CITY OF ALBUQUERQUE

Re: Red Robin
2100 Louisianan Blvd
30-Day Temporary Certificate of Occupancy- Transportation Development
Architect's Stamp dated 9-16-16 (J19-D058B)
Certification dated 3-1-17

SITE PLAN FOR BUILDING PERMIT

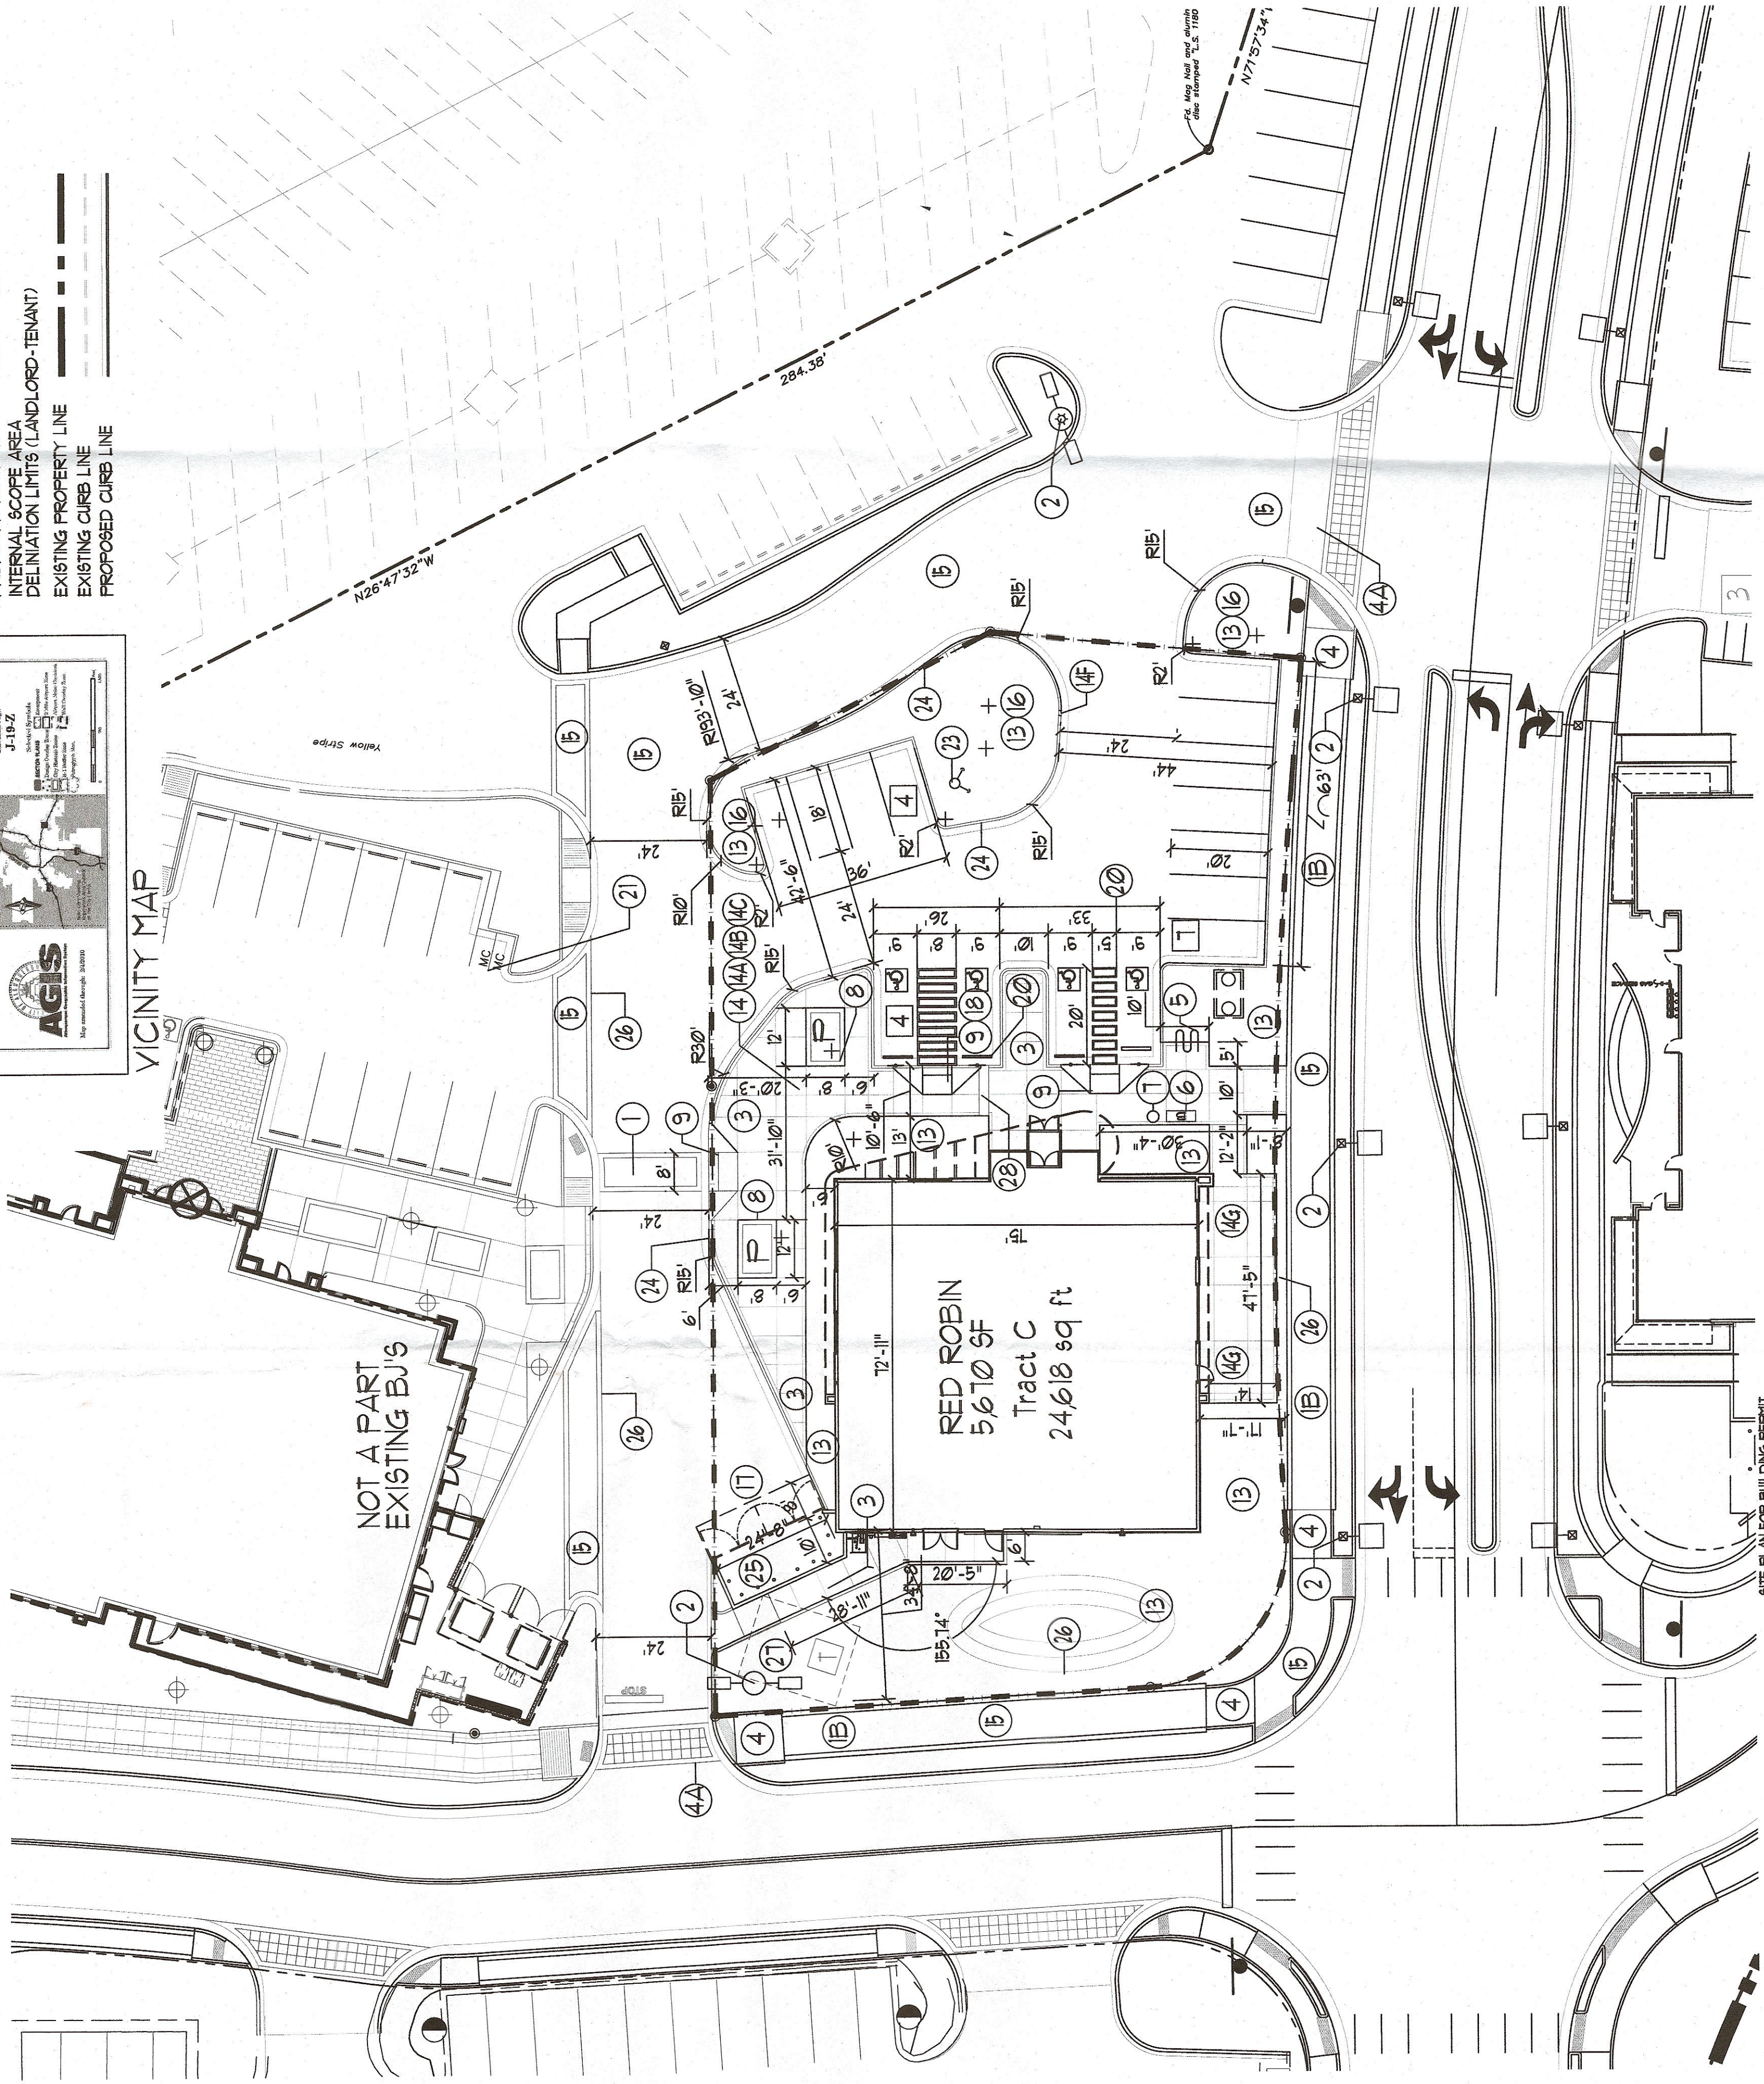
1. The ADA access aisles shall have the words "NO PARKING" in capital letters, each of which shall be at least one foot high and at least two inches wide, placed at the rear of the parking space so as to be close to where an adjacent vehicle's rear tire would be placed. (66-1-4.1.B NMSA 1978)
